RE: Chaparral Elementary School Portable Relocation
Traffic Circulation Layout
Engineer's Stamp Dated 4-14-15 (File: F10-D005)

Attached is the revised Traffic Circulation Layout sheet submitted for approval. The revisions have been performed based on your comments from the original submittal. Two hardcopy sets will be delivered to your office in addition to this electronic submittal.

A1 TRAFFIC CIRCULATION & FOUNDATION LAYOUT
1" = 20'

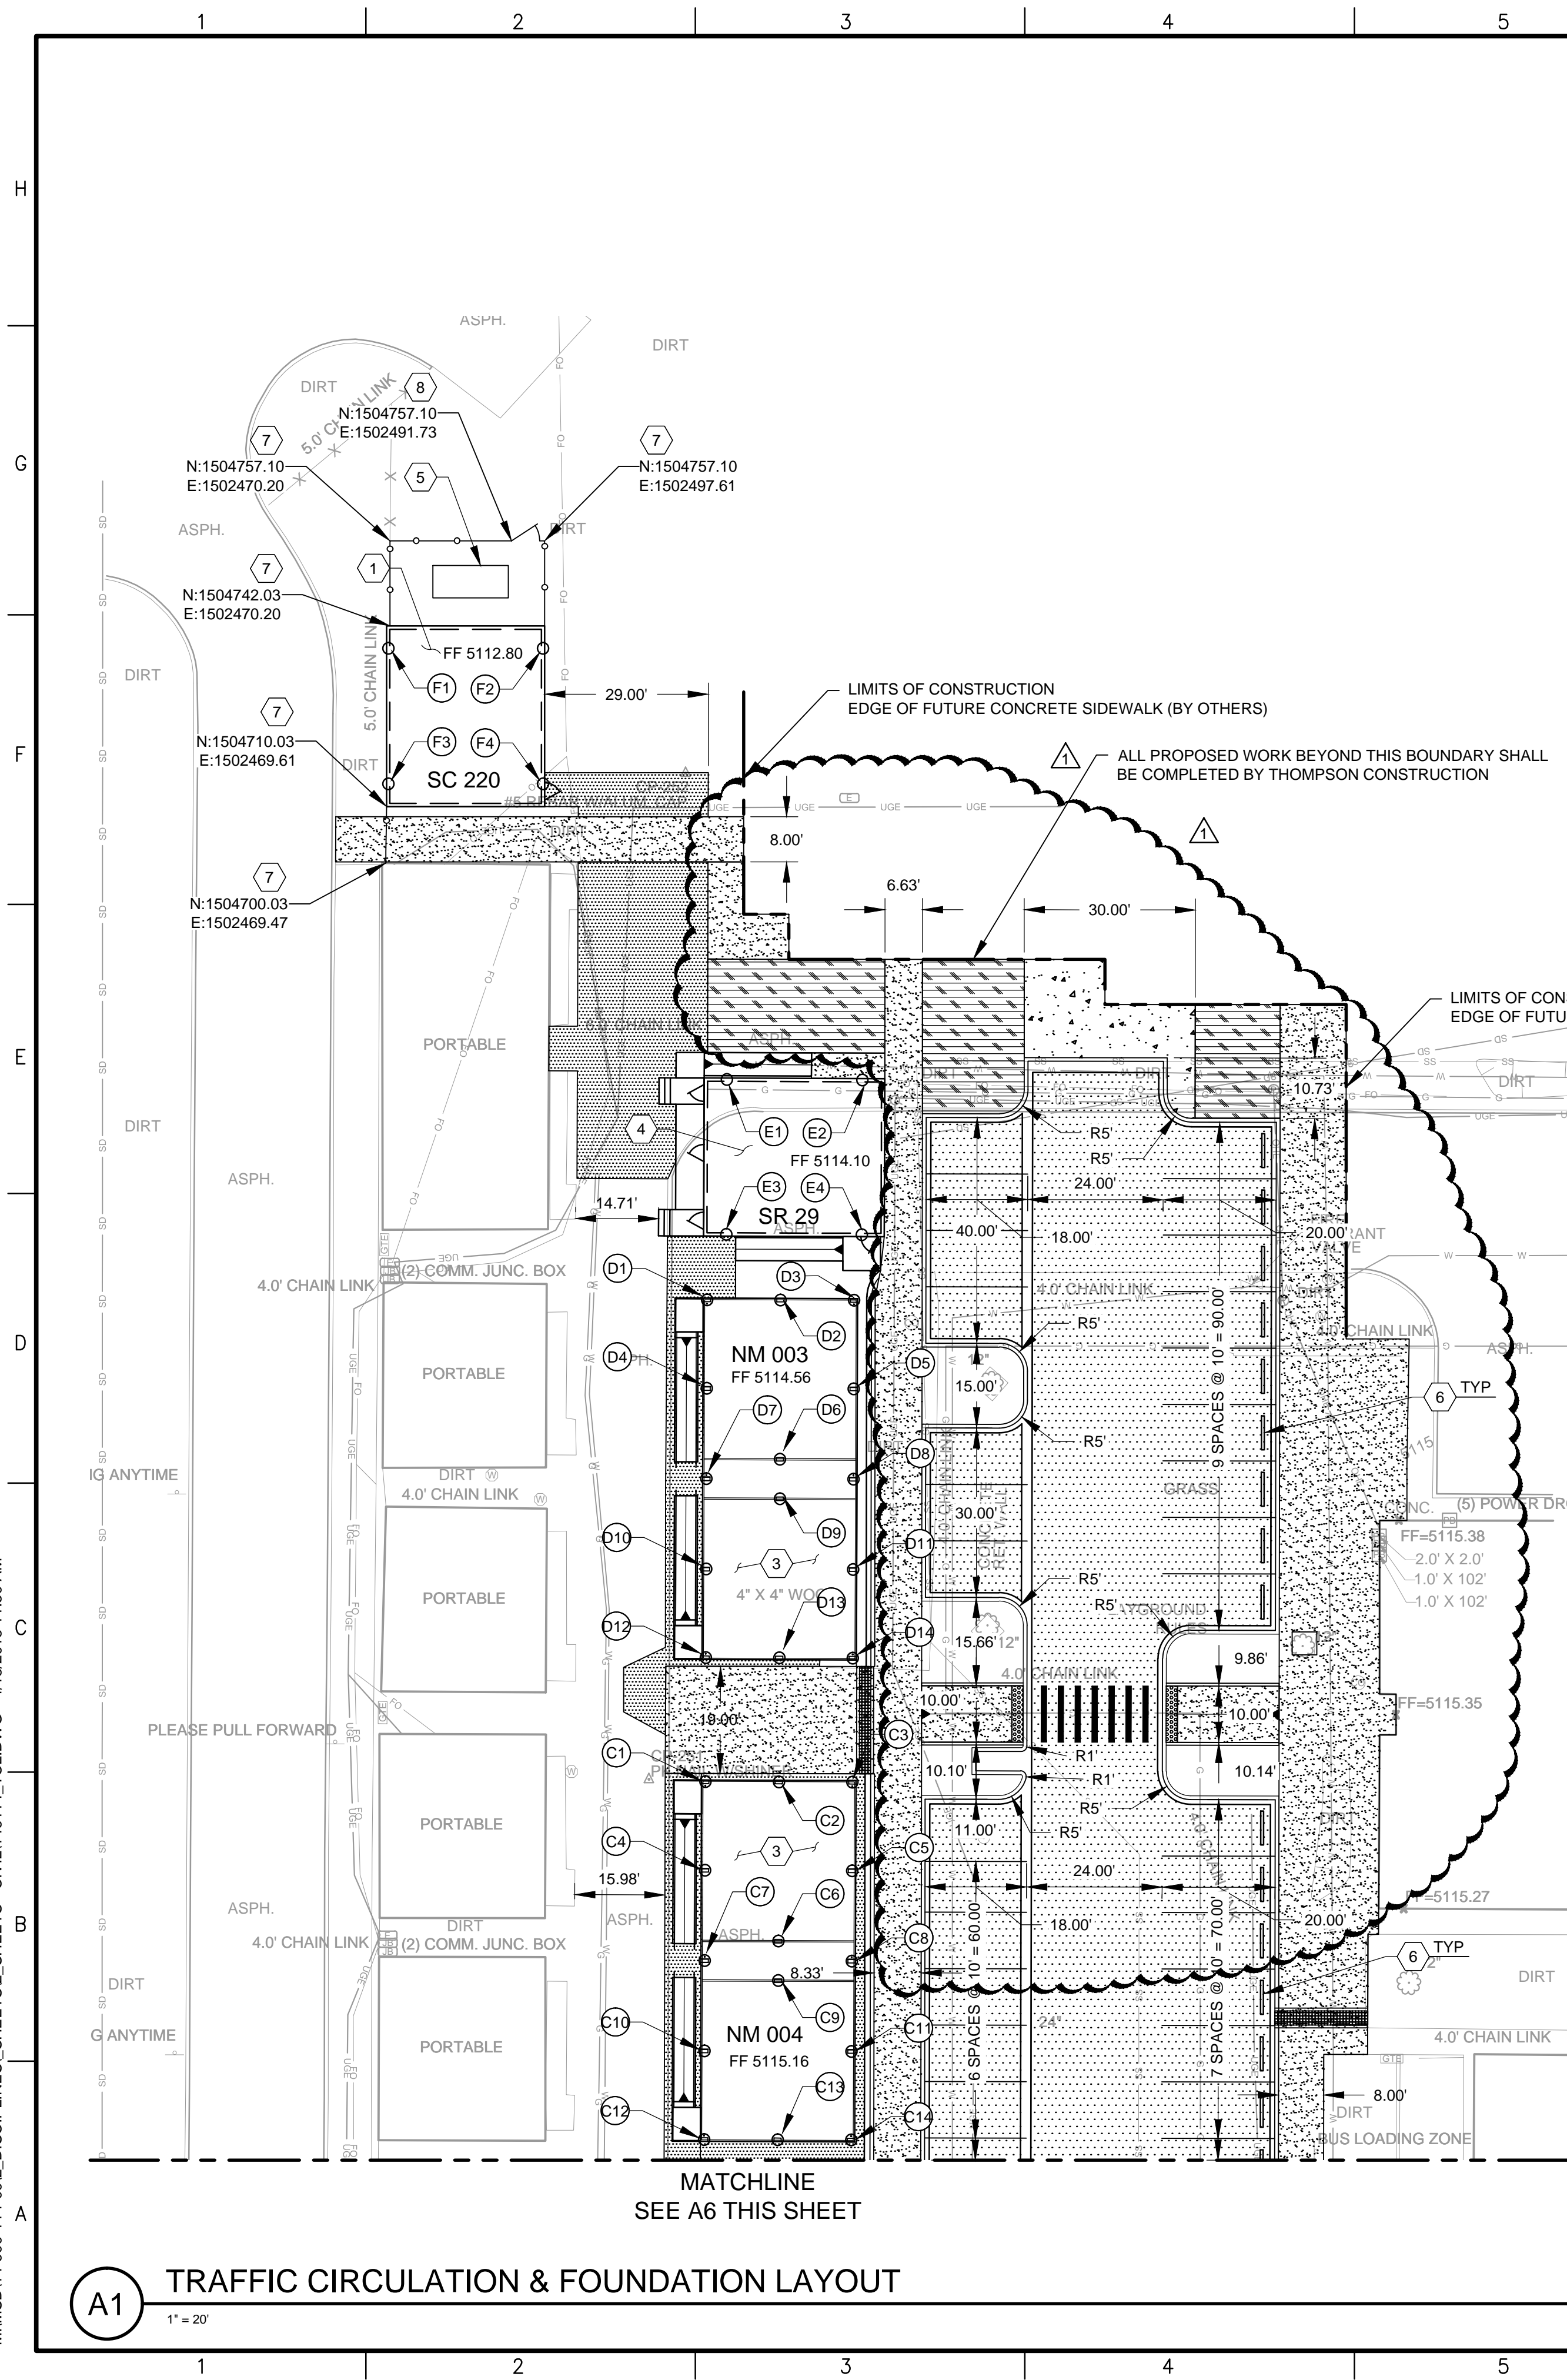
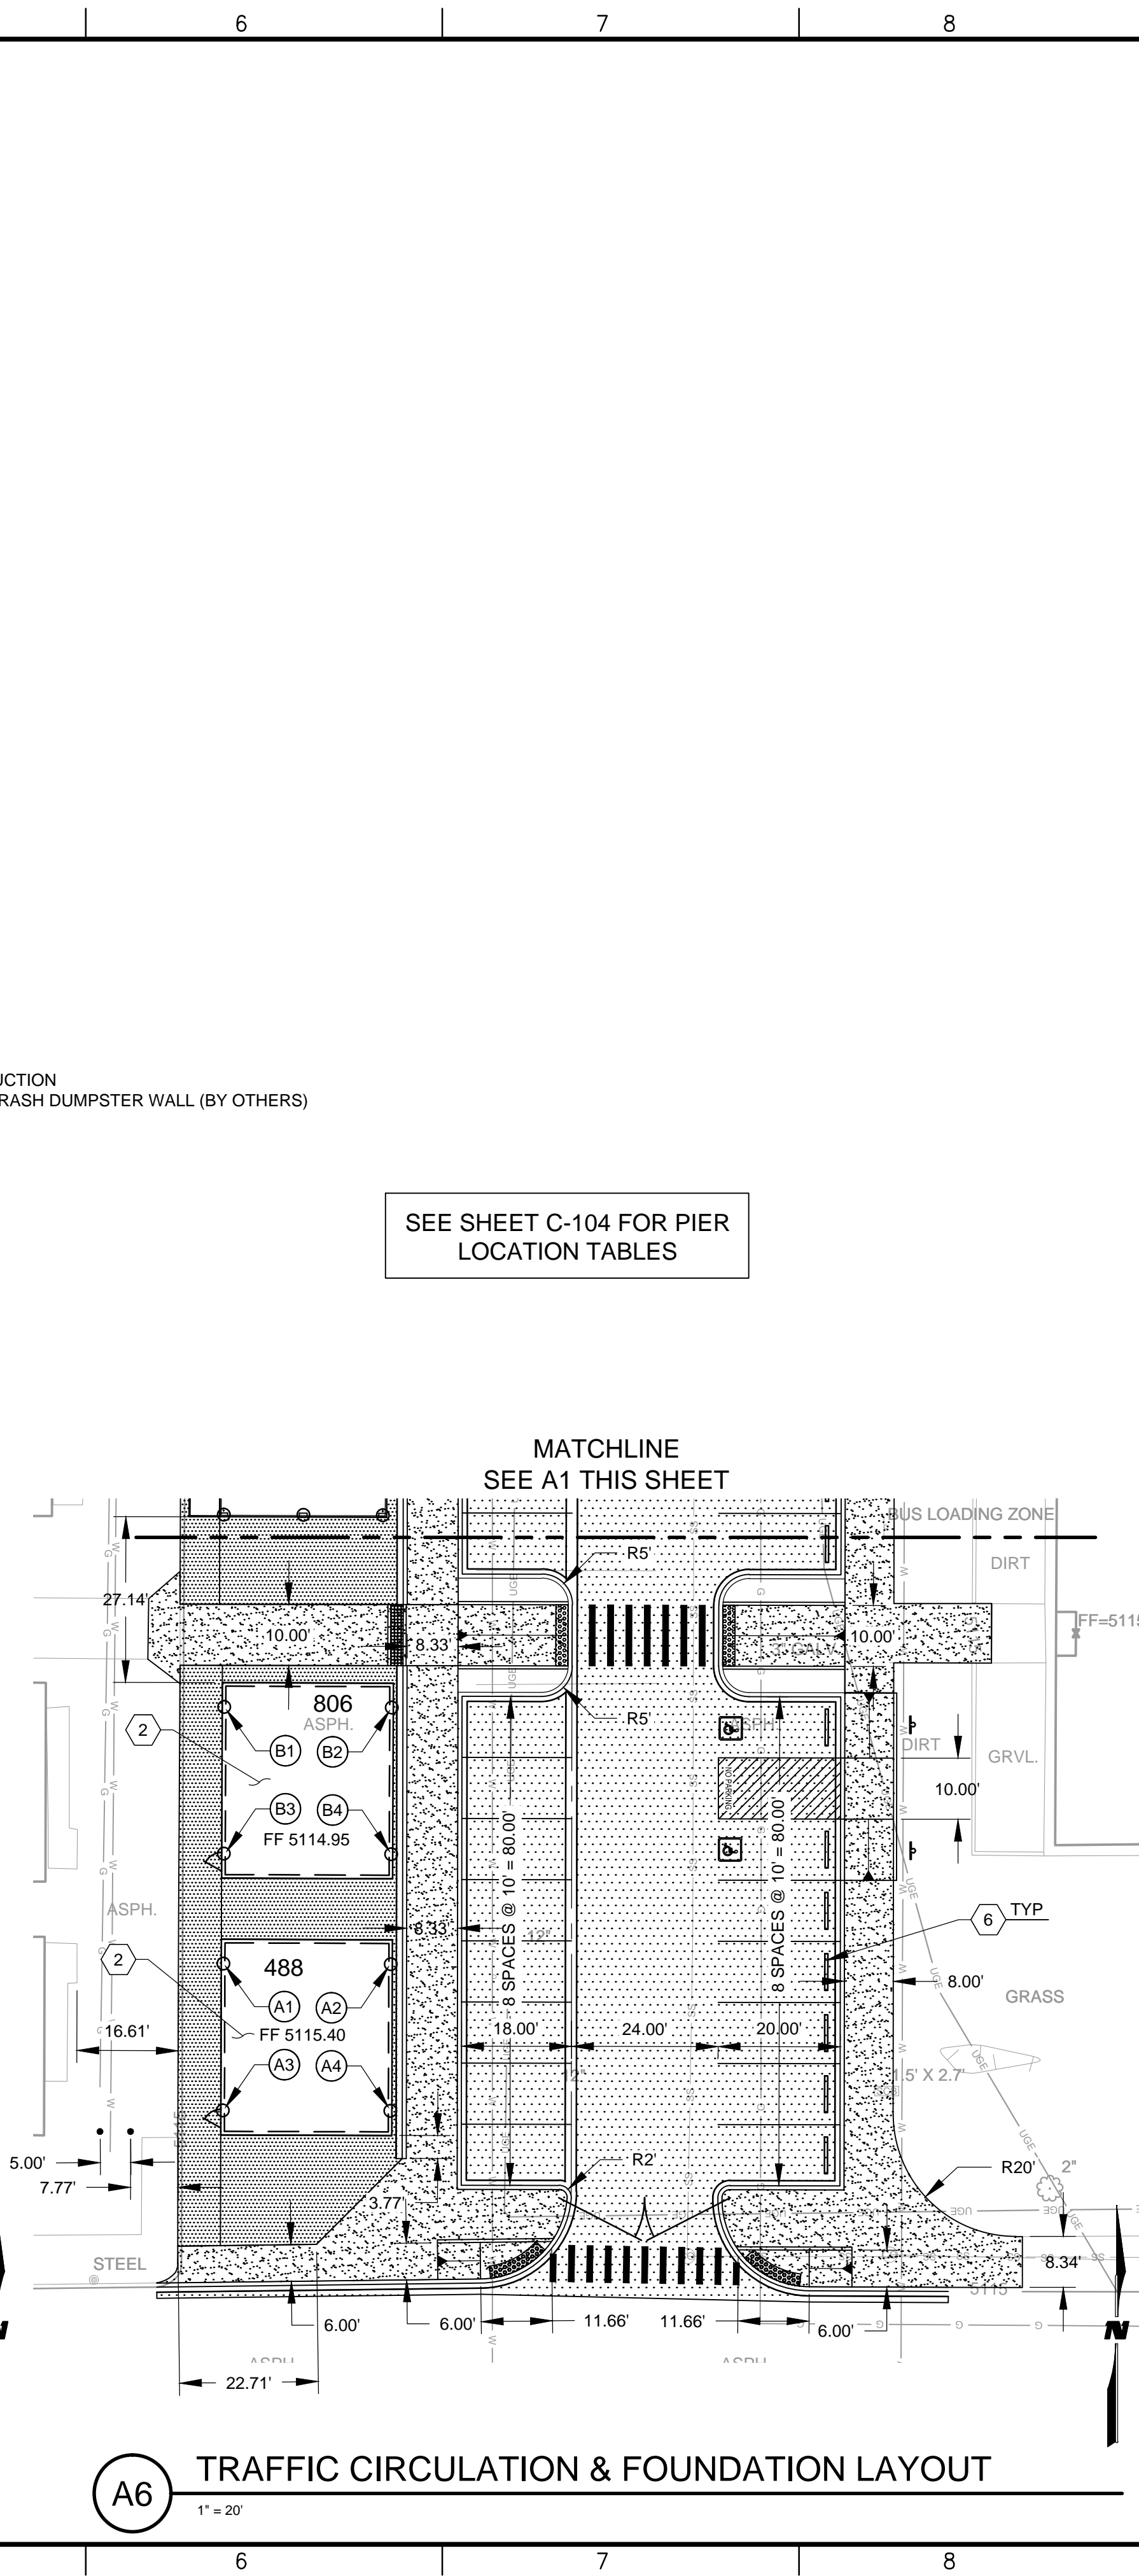
1. Labels have been added to indicate the curb radii at the entrance into the new parking lot.
2. A dimension label has been added to show the width of the keyway at the far northern end of the proposed parking lot.
3. All existing doorways have been shown for the portables. Labels have been included to show a 12:1 maximum slope on all proposed ramps leading up into the portable buildings, and a minimum 4-foot by 4-foot landings at the top of the ramps.
4. Slope labels showing 2% max cross-slope on the walkways have been included and labels indicating/showing areas where the existing asphalt is to remain.
5. A keynote was added to reference the sheet number for the curb ramp detail.
6. A keynote was placed next to the words "NO PARKING" on the ADA van access aisle. The note indicates that the dimensions of letters to be a minimum one foot high and two inches wide.
